9. Vicarage Gardens,
Cropredy.

Planning Ref. 20/02060/F

# SITE LAYOUT PLAN

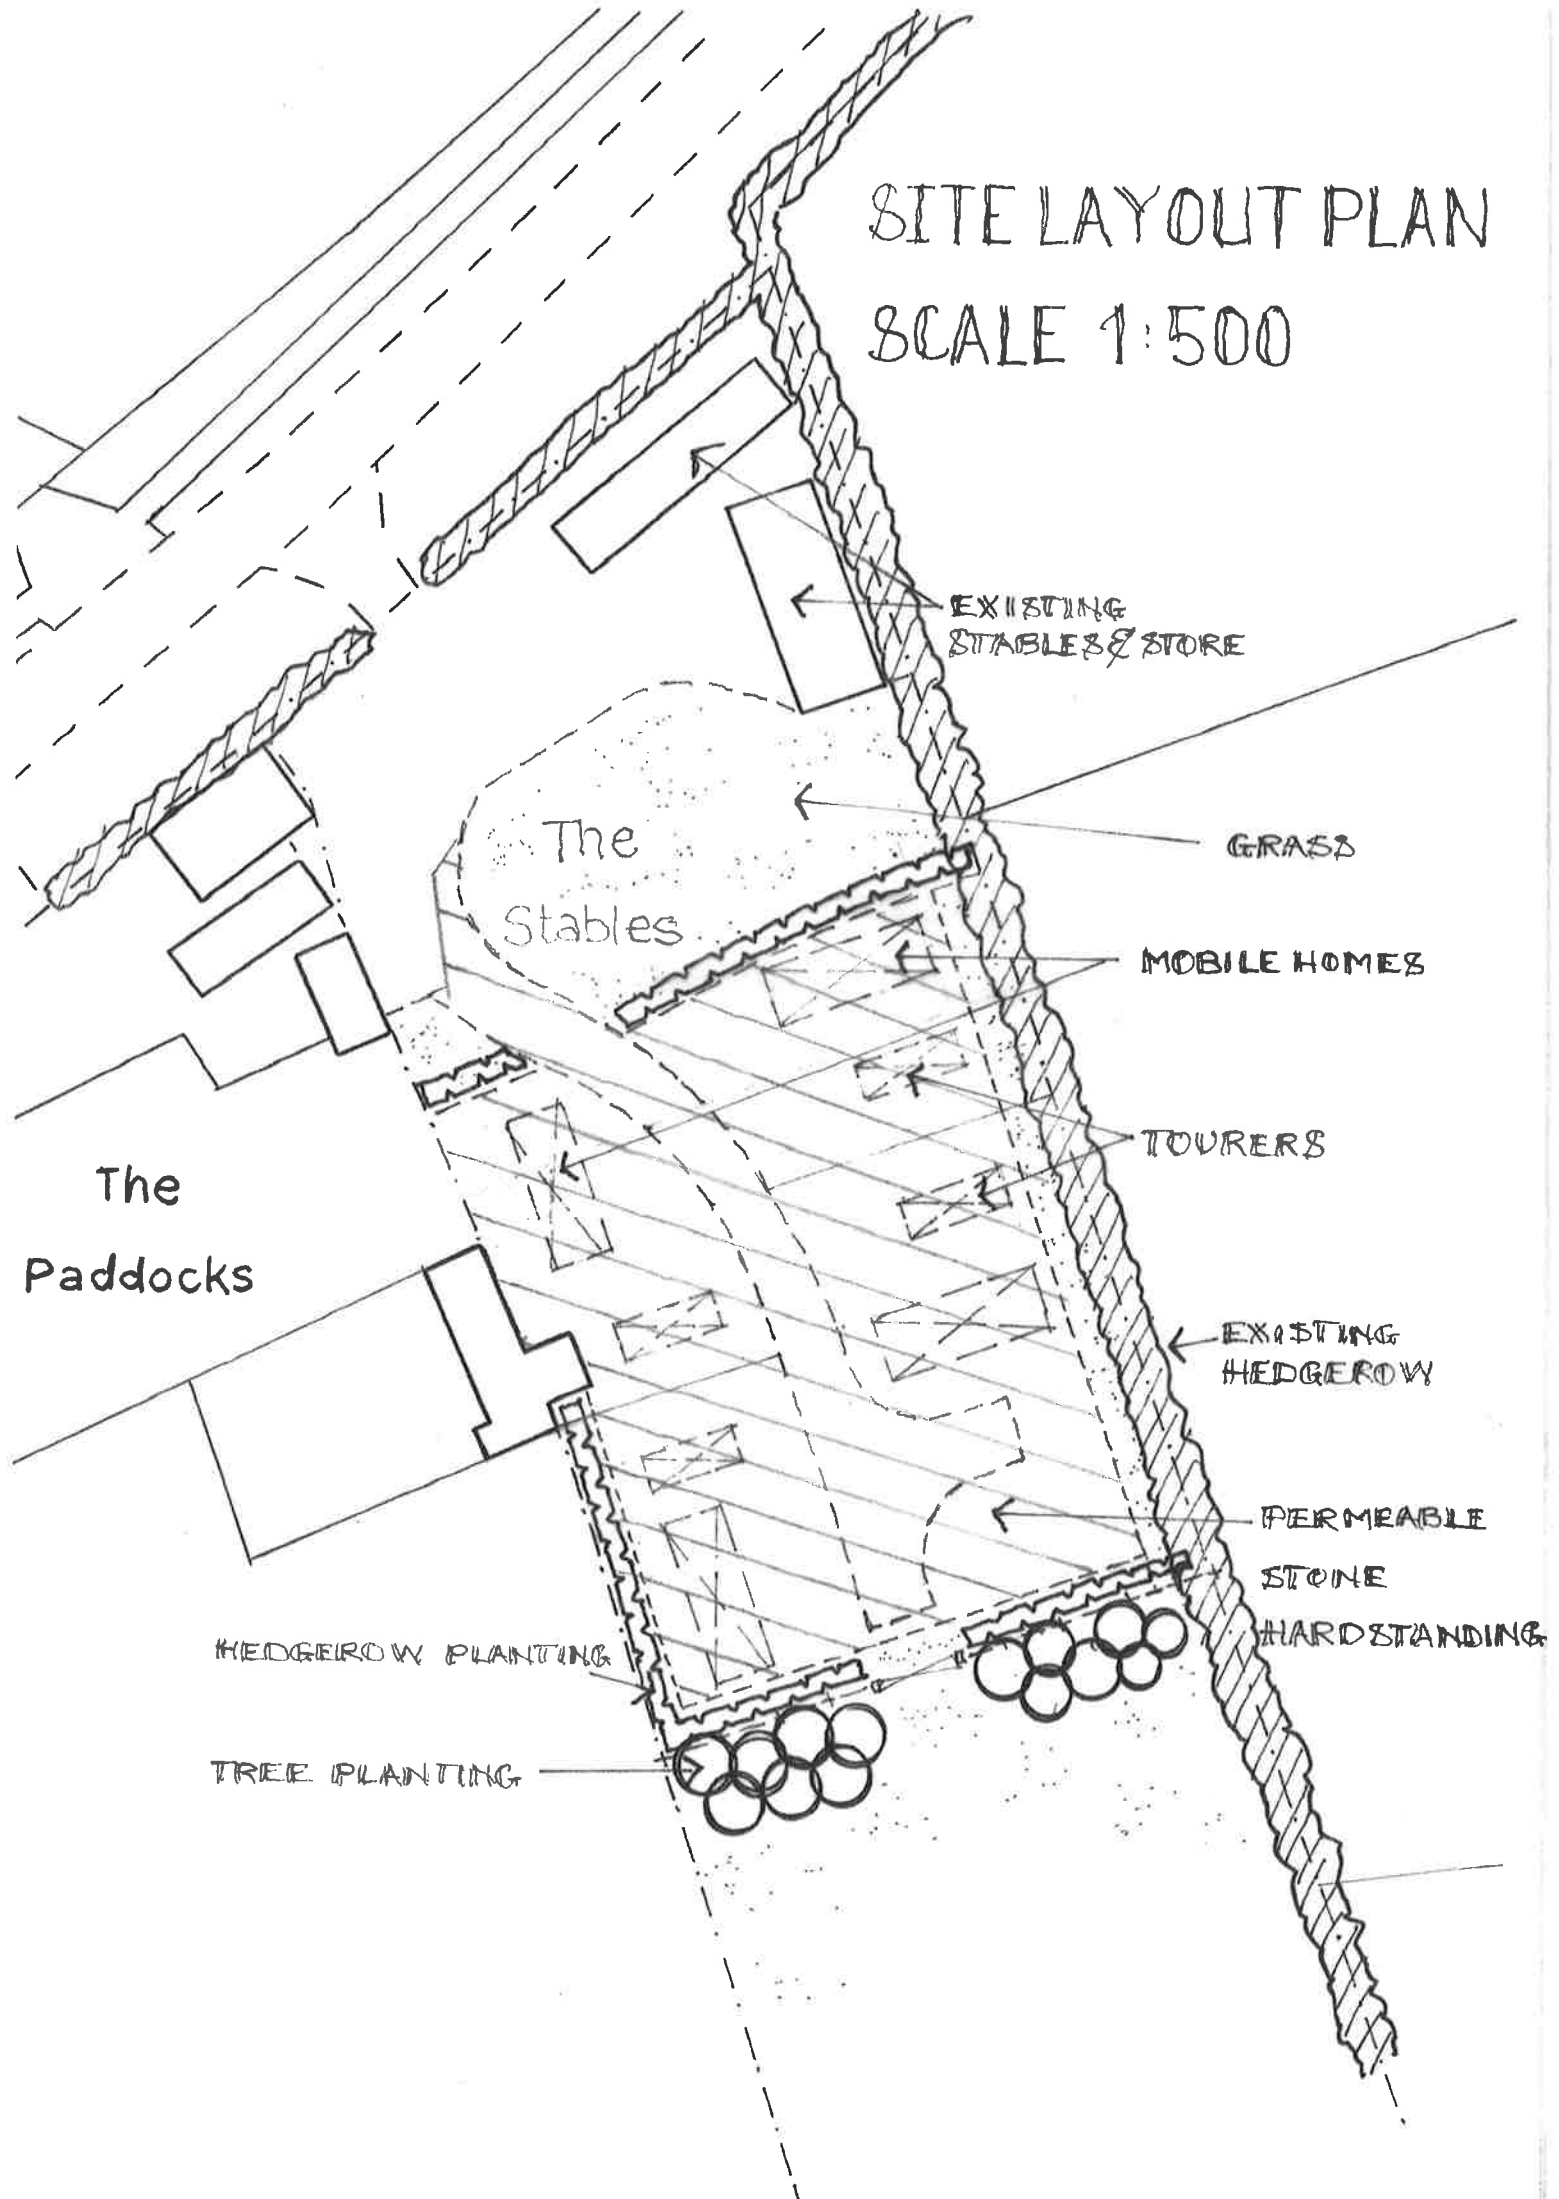
1. The area floods quite often
2. Problems with sewage.

3. Access to the site! The road
is busy with general traffic,
+ cars + buses are daily
delivering + collecting children
from school. Sturley Branch
